Application for Planning Permission for Works or Extension to a Dwelling

Development: Proposed front extension (to replace existing porch/conservatory), rear extension, new roof tiles and render to cover existing brickwork and loft conversion to include front and rear dormers and removal of barn hips to the side.

Location: 8 Laburnum Close Ferring BN12 5EJ

I regret that I am unable to accept your documents as a valid application until the following item(s) have been received or resolved :-

Drawing Number: AR-201-03 Revision: Revision

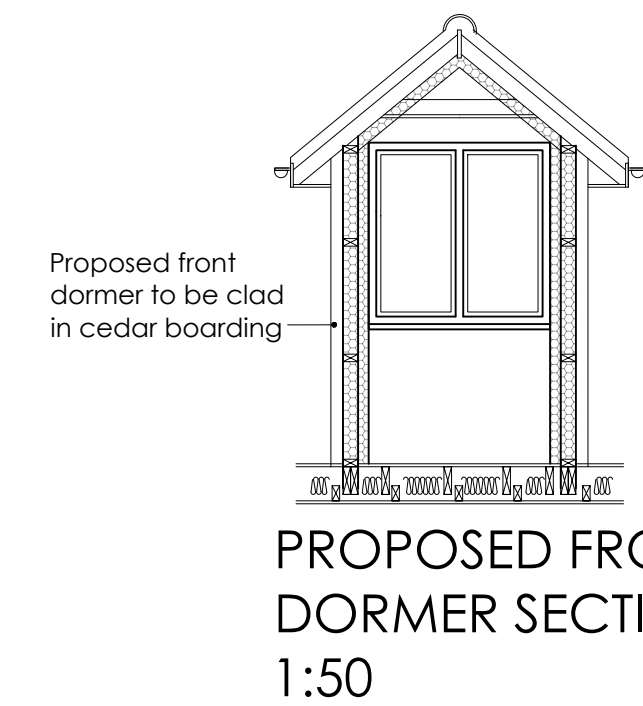
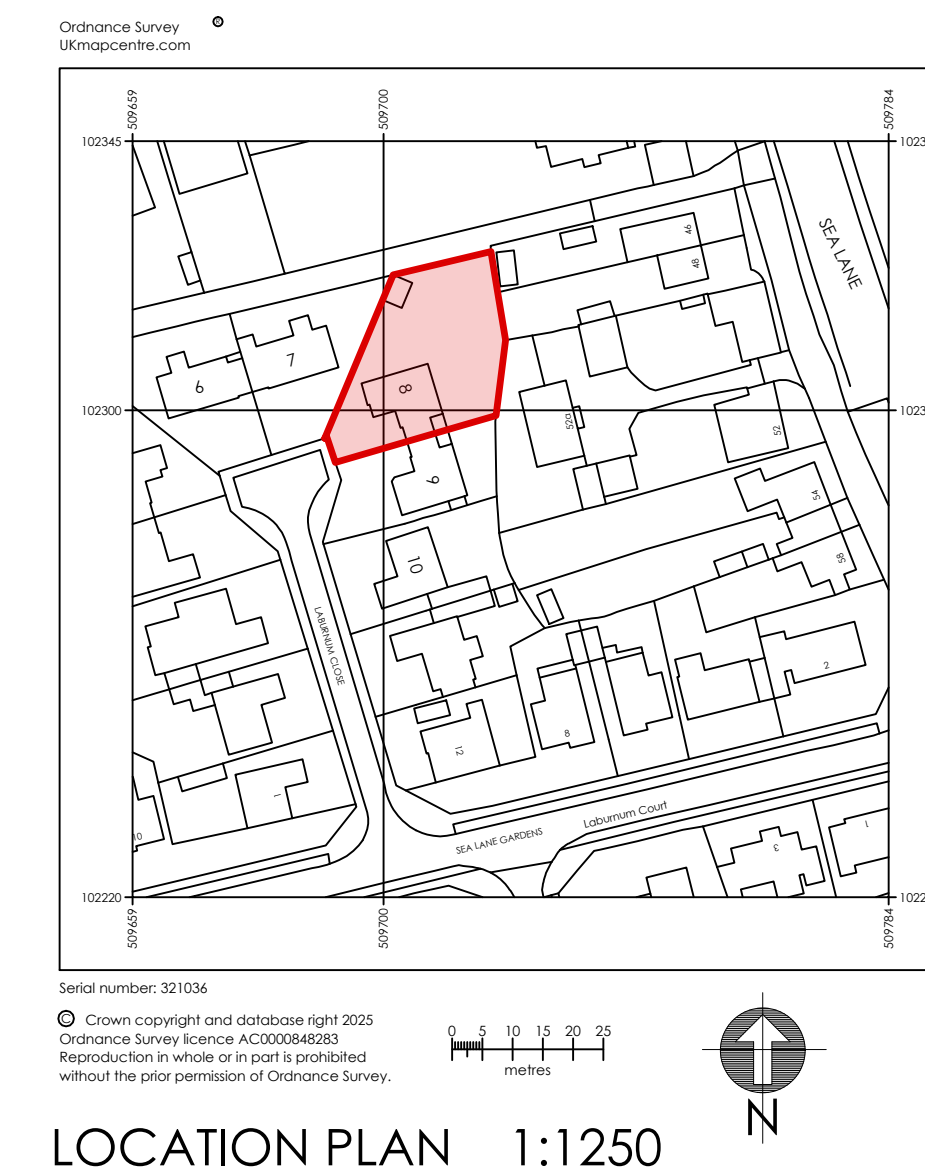
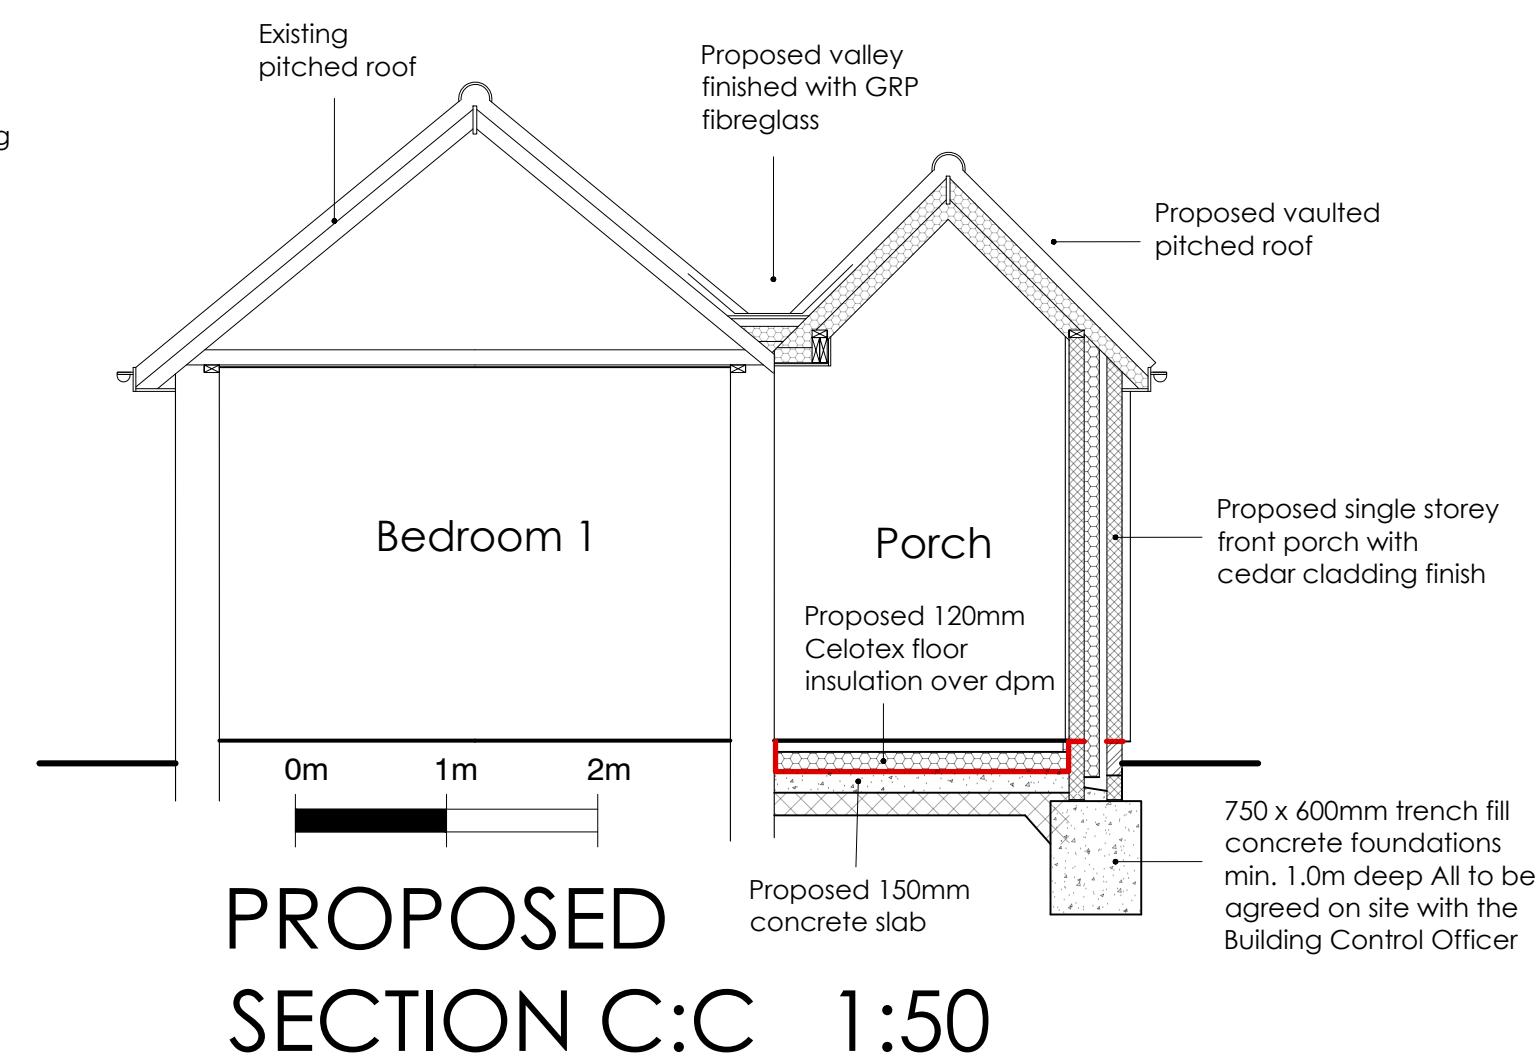
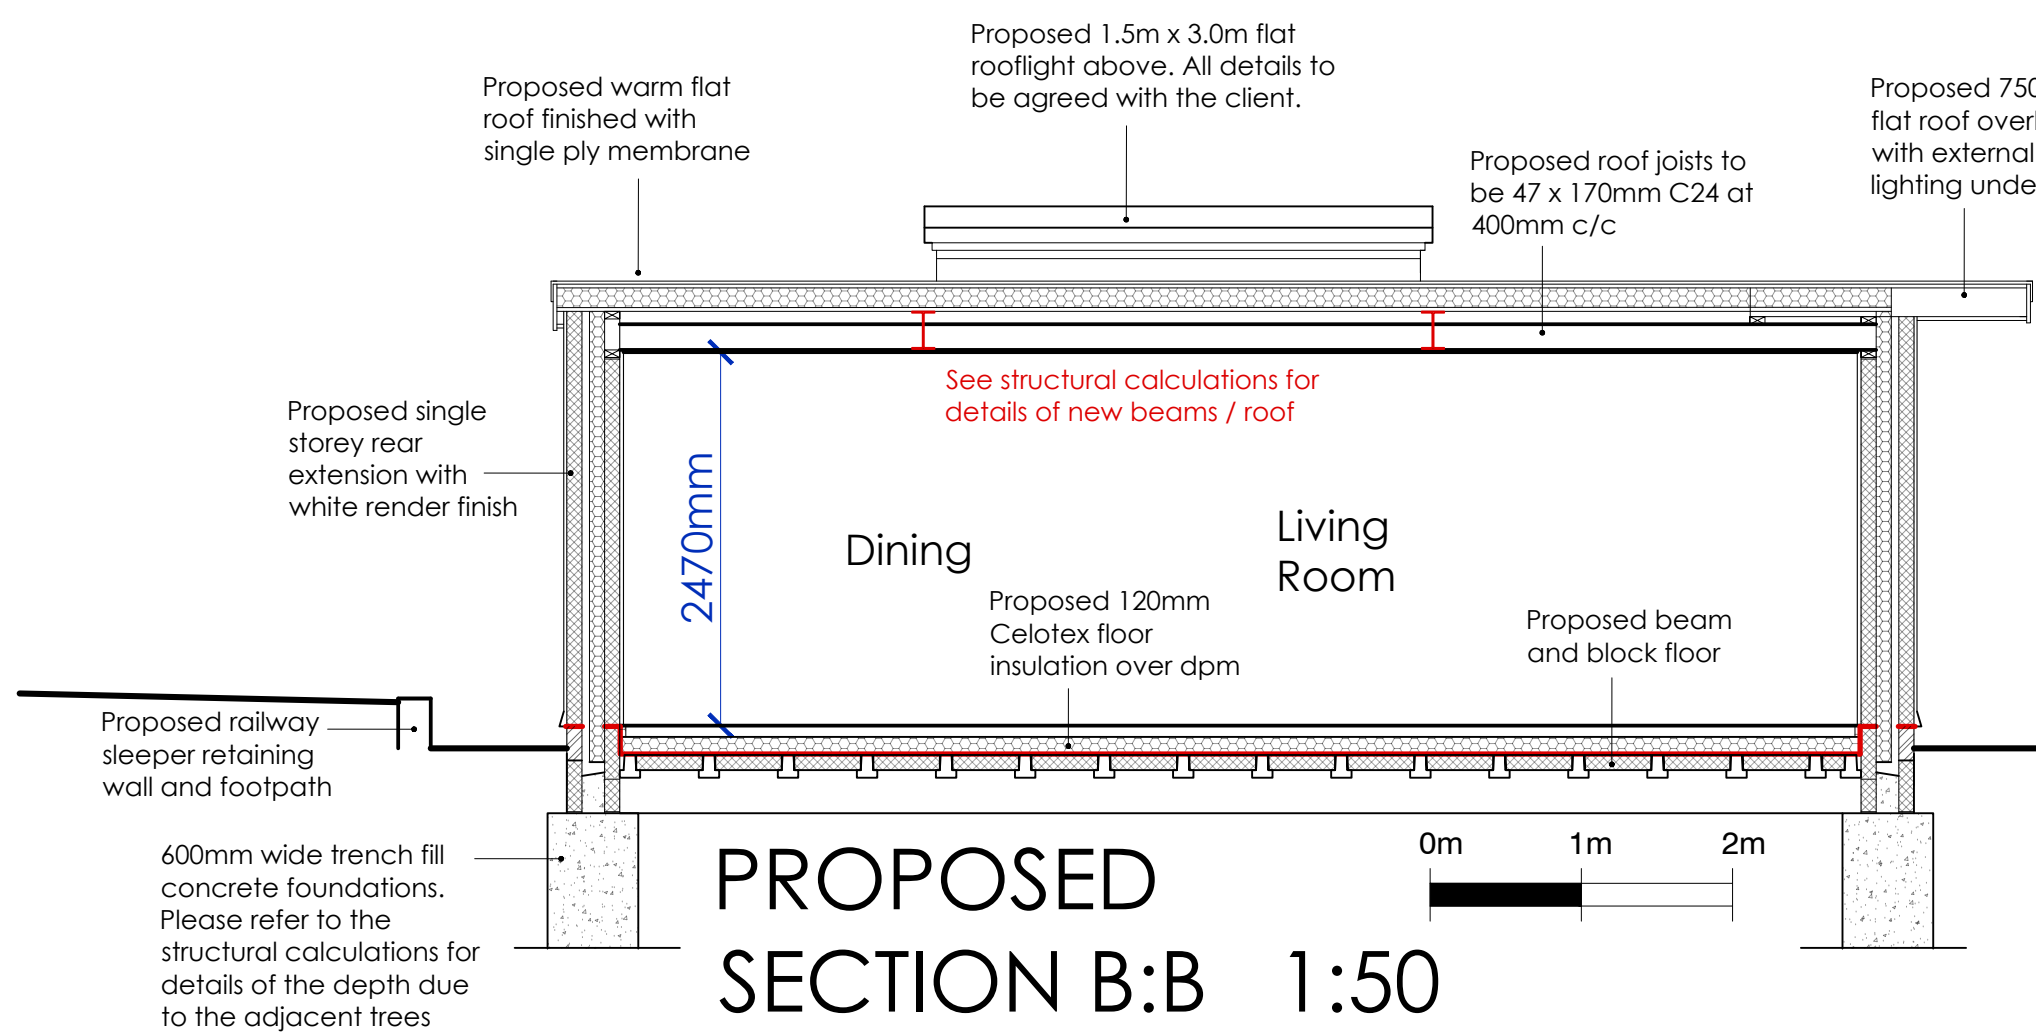
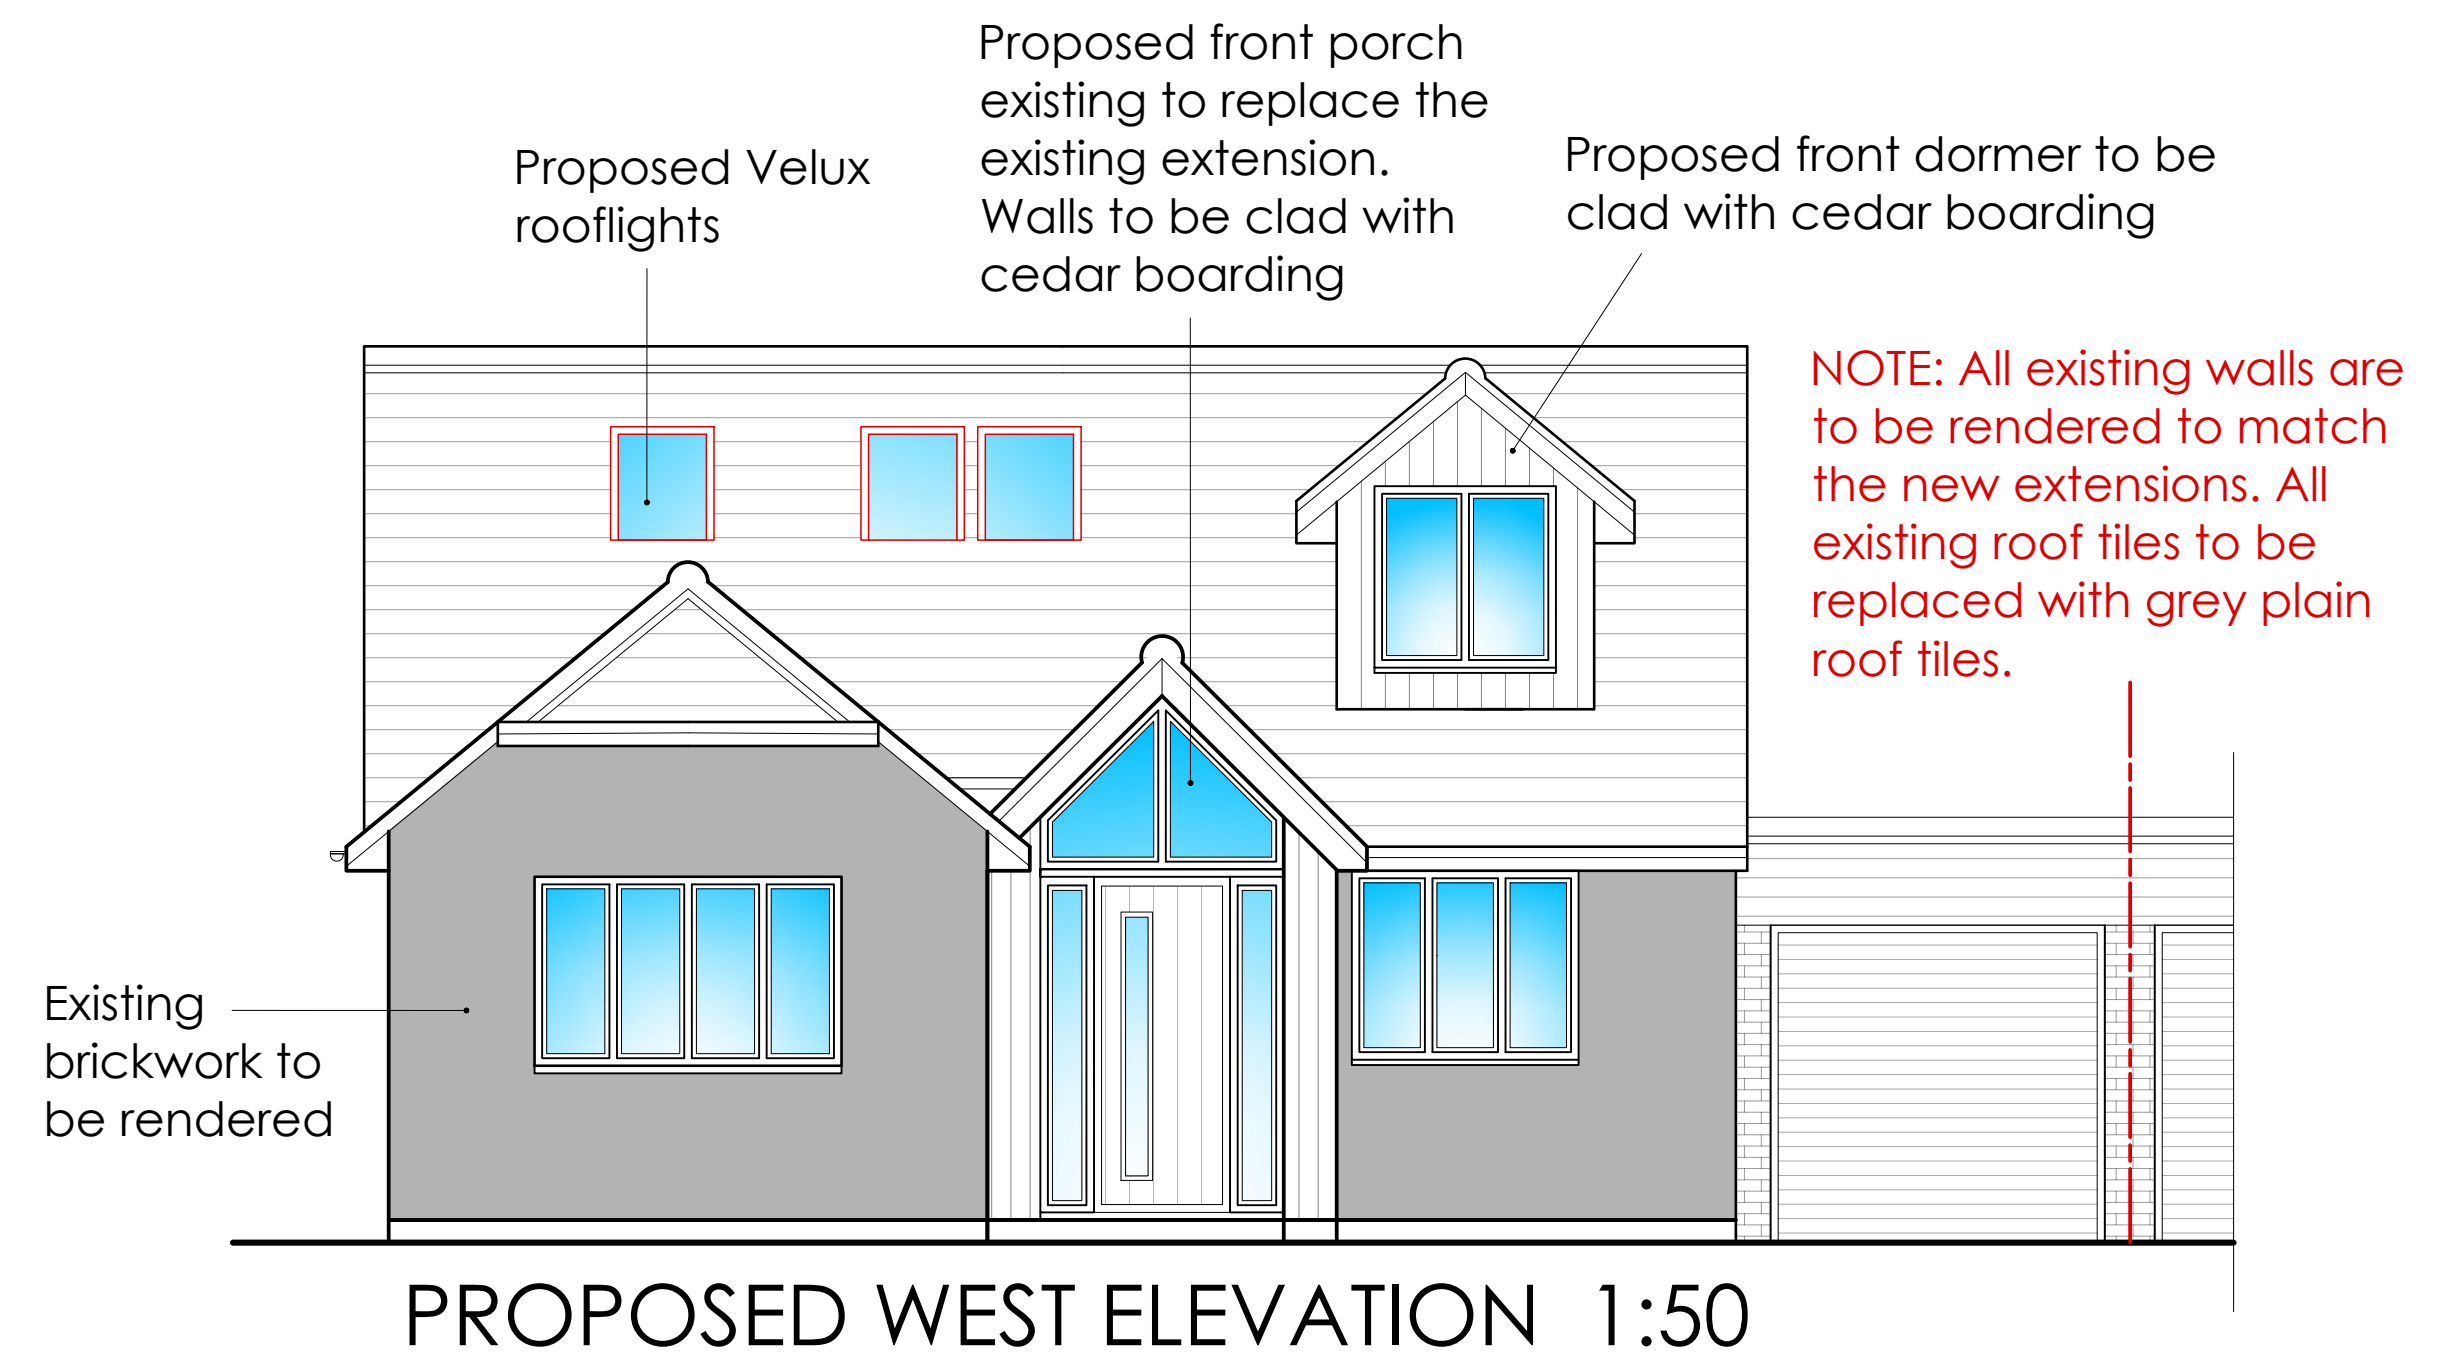
Proposed East Elevation

The proposed east elevation has a 1:100 scale listed, however is measuring to 1:50, please review and amend.
